ADC PARKS & GREENSPACE ARBORICULTURE

PLANNING APPLICATION: R/199/14/T

ADDRESS: Communal land at Willowhayne Mews Preston Paddock Rustington  
BN16 2AF

BRIEF DESCRIPTION: Fell 1 No Silver Birch tree

Drawing No: **Tree Retention and Protection**
Drawing

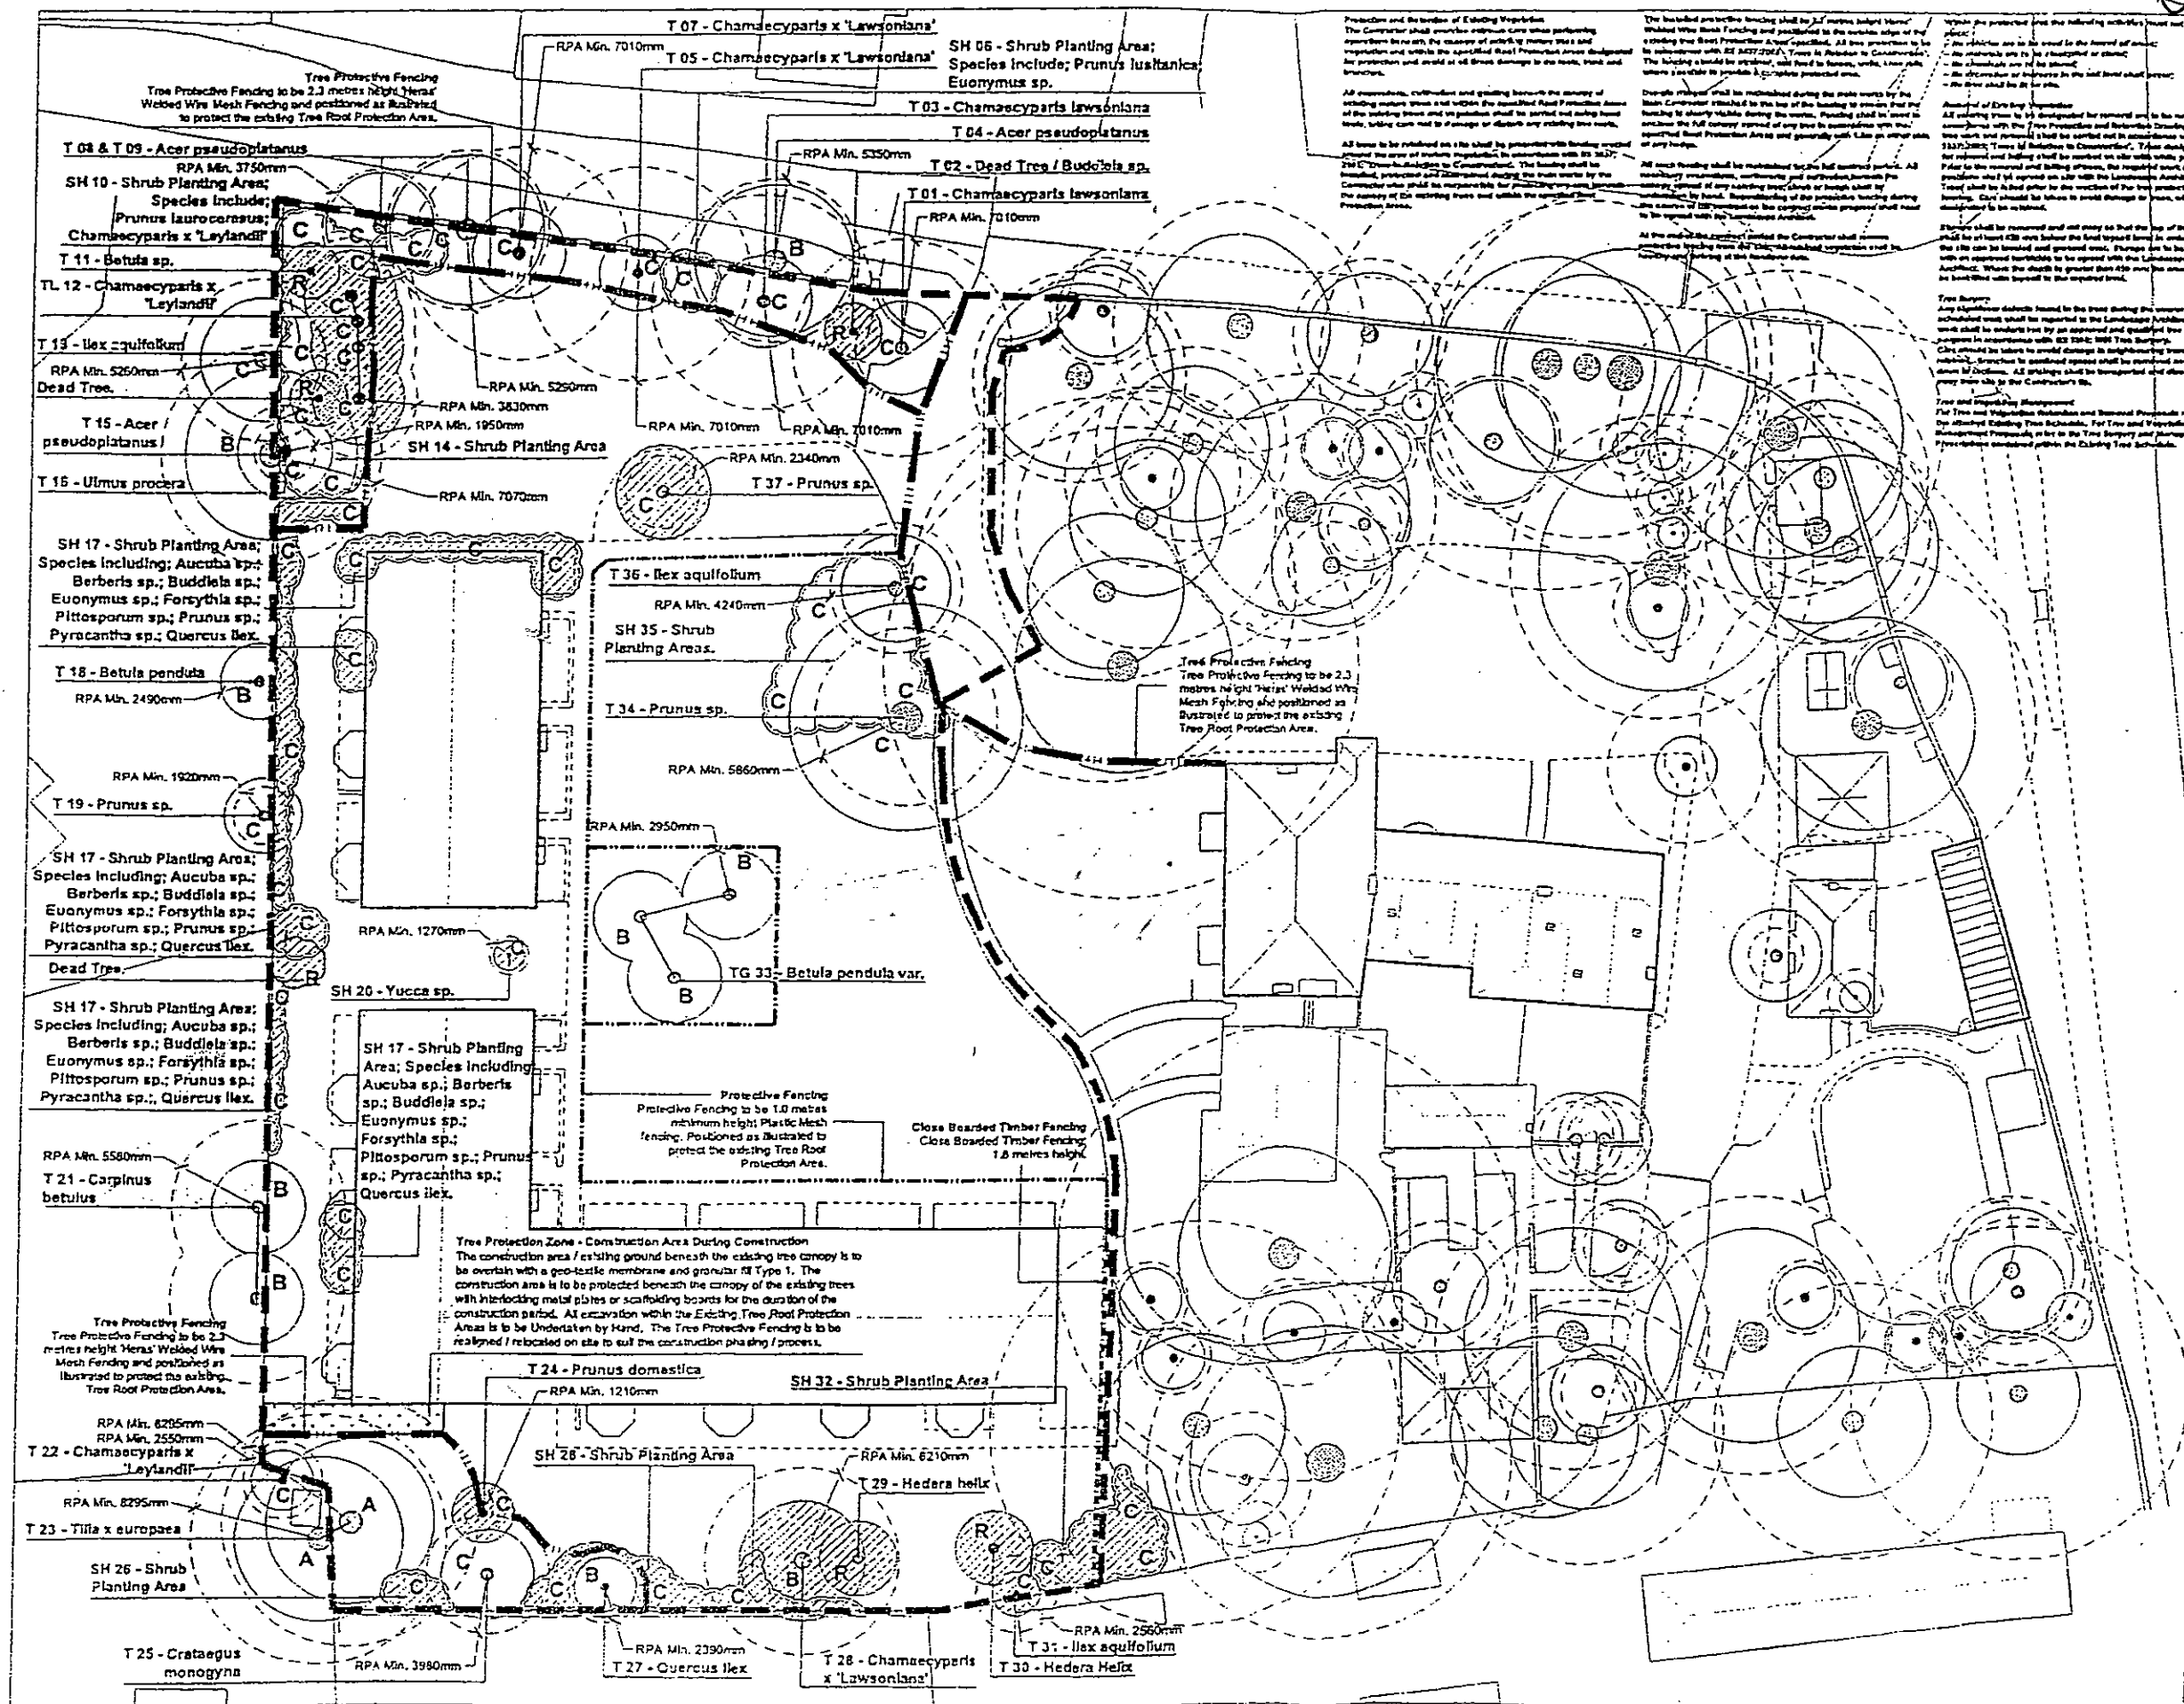
- This tree is situated in the high amenity area Preston paddock, which has a varied mix of juvenile to over mature specimens that area spread across the landscape
- This outlined individual is quite clearly dead standing. From the site inspection it is clear that this tree was not exhibiting any signs of life in the crown (considering it is part of a group of 3, and the other 2 individuals are in full leaf. This would indicate this tree has not just dropped its leaves due to a shock event occurring, as it would of affected all three trees).
- It should also be noted that this 'dead standing' tree was a mature specimen prior to death, so it is quite possible that this was just the natural end of this particular individual's lifecycle.

- **As this is a 'dead standing' tree, it would be my recommendation to fell this tree**, as it is situated in a location where there is the potential for it becoming a hazard, if left to deteriorate further.

- As this is a TPO'd tree there will be **the will be a requirement to replant with a replacement tree.**

- The replacement tree should be **located in the same location as the felled tree** (I did not pick up on any pathogens present that could affect the replacement). The replacement tree should have an **expected mature height of at least 4 meters.**
- Suggested replacement species would include:
  1. Downy Birch *Betula pubescens*
  2. Chinese Red-Barcked Birch *Betula albo-sinensis*
  3. Swedish Whitebeam *Sorbus intermedia*
